CITY OF ALBUQUERQUE

**Re: HME Specialists Office/Retail, Grading and Drainage Plan
Engineer's Stamp Date 12-06-13 (A12D008C)**

DRAINAGE REPORT

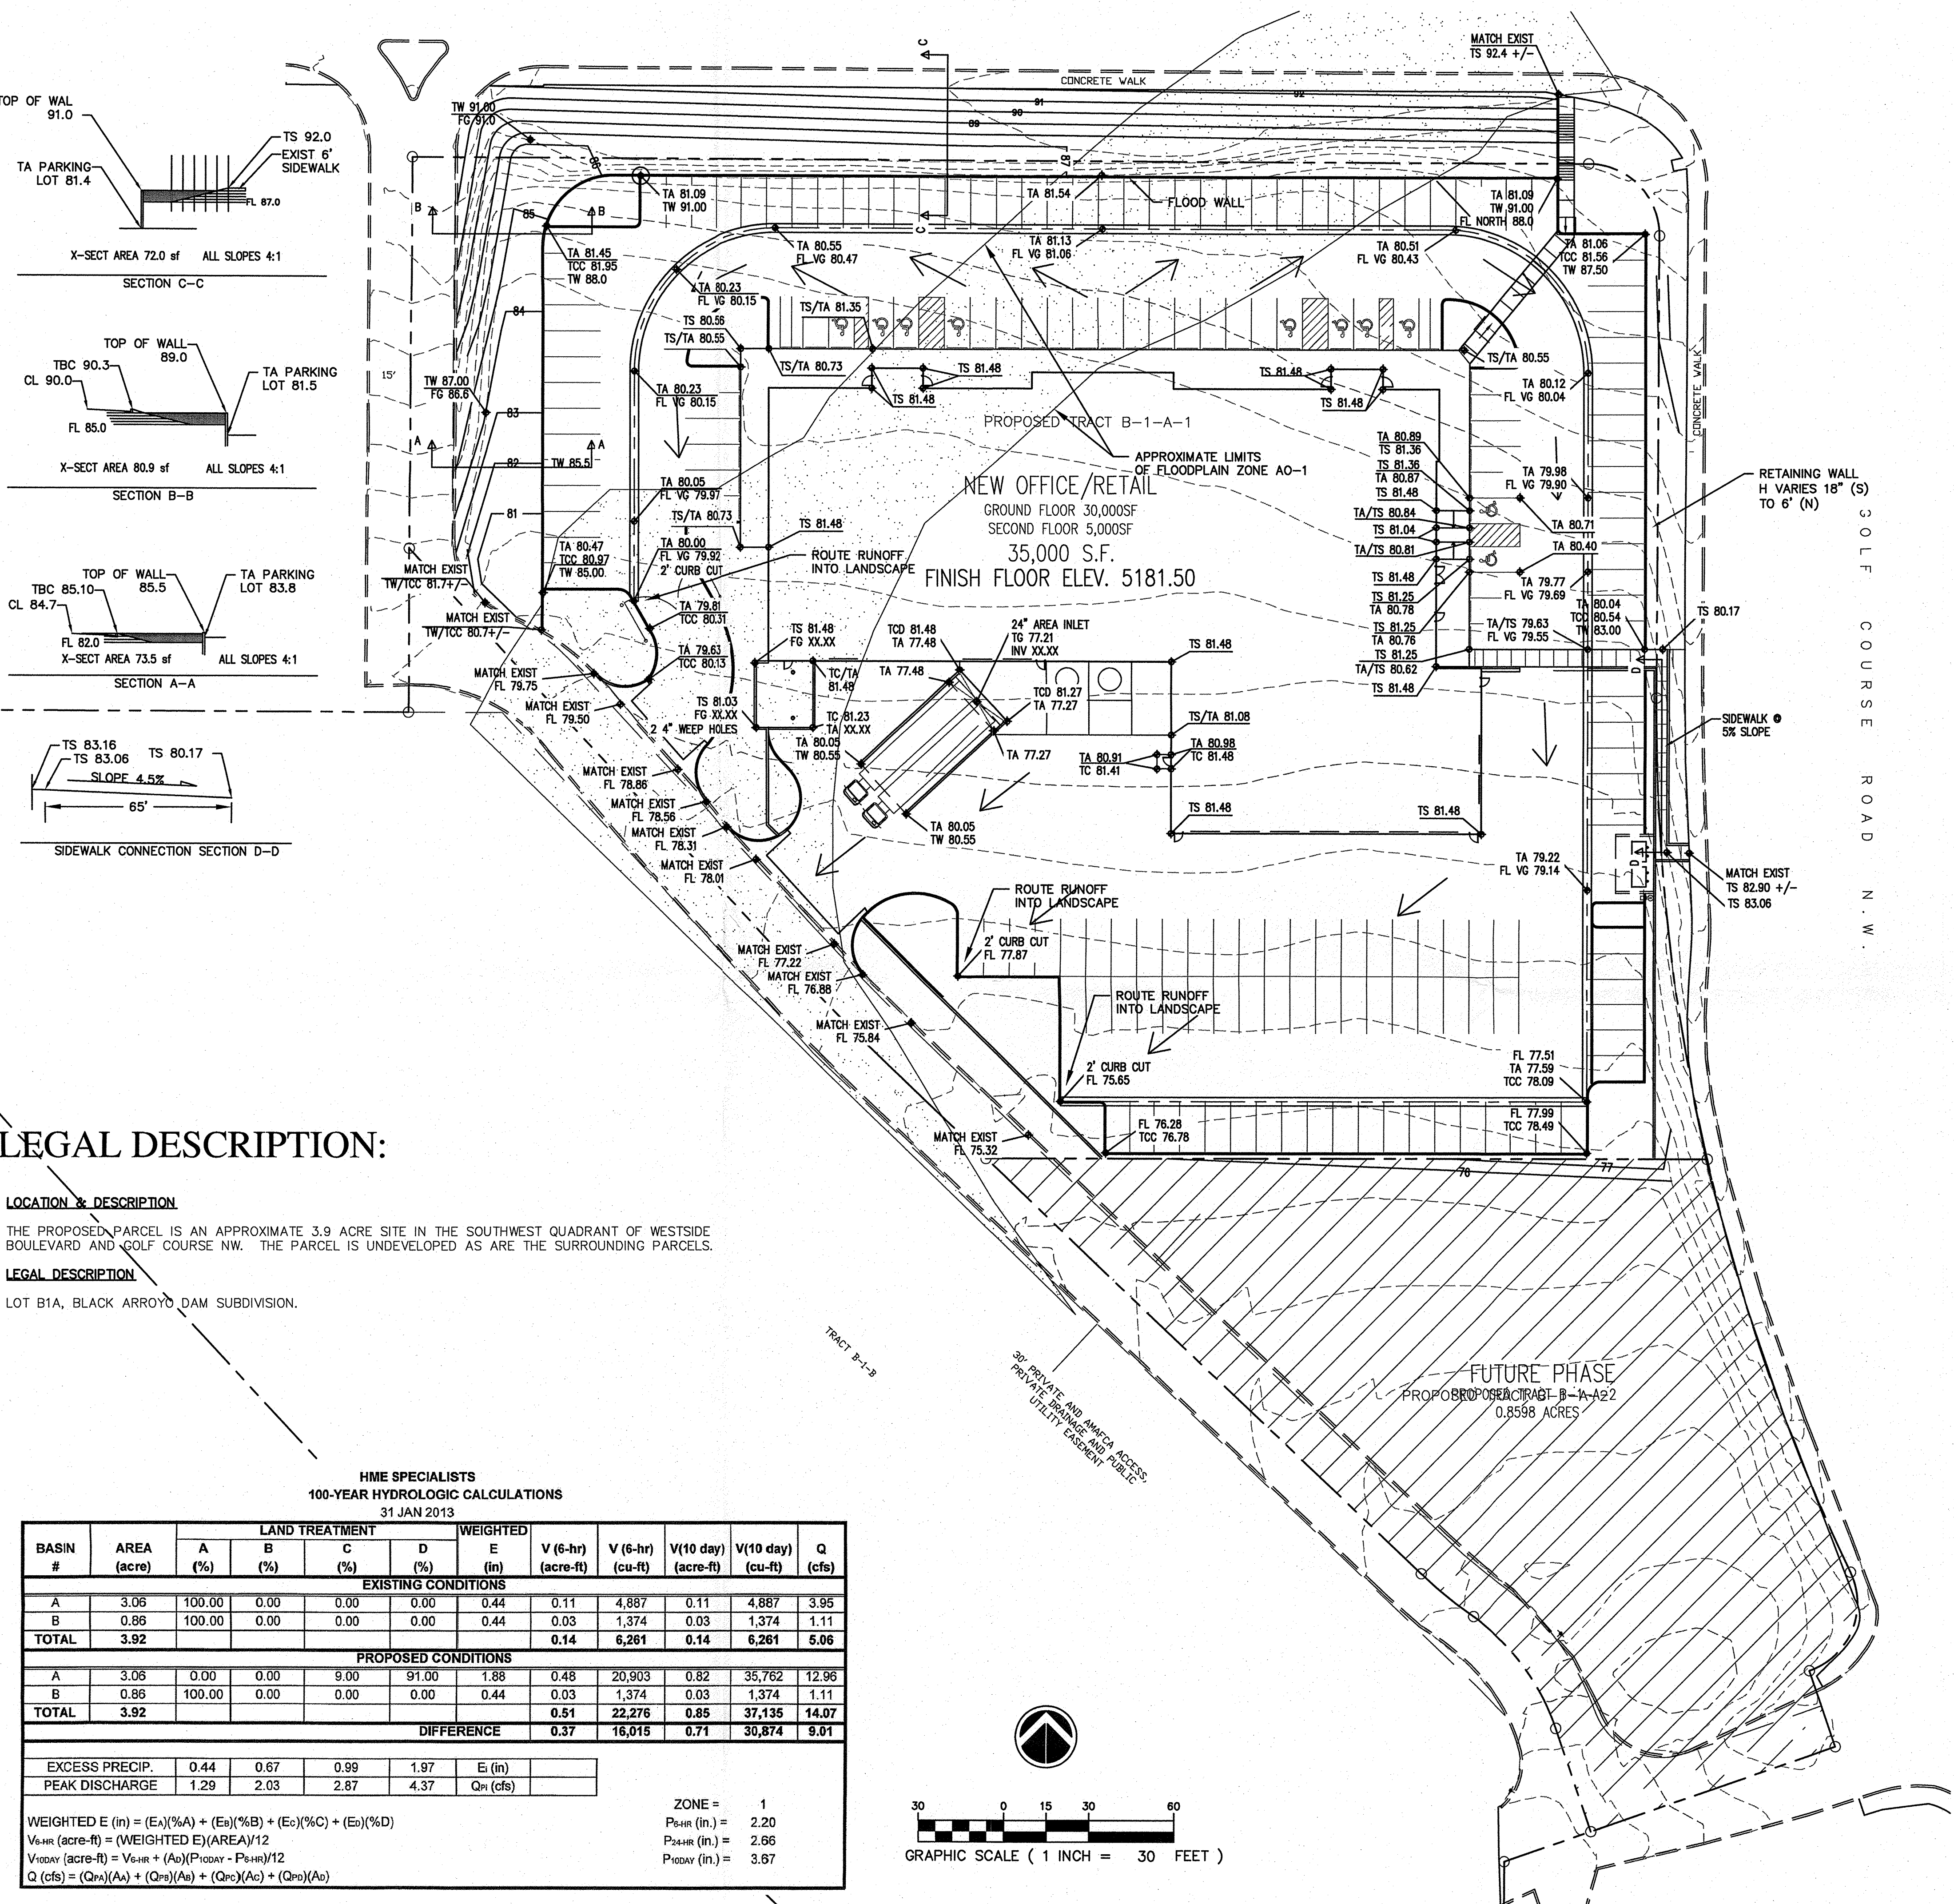
- Remove the retaining wall/headerwall along the sidewalk where it enters the City of Albuquerque right-of-way along Golf Course Road.
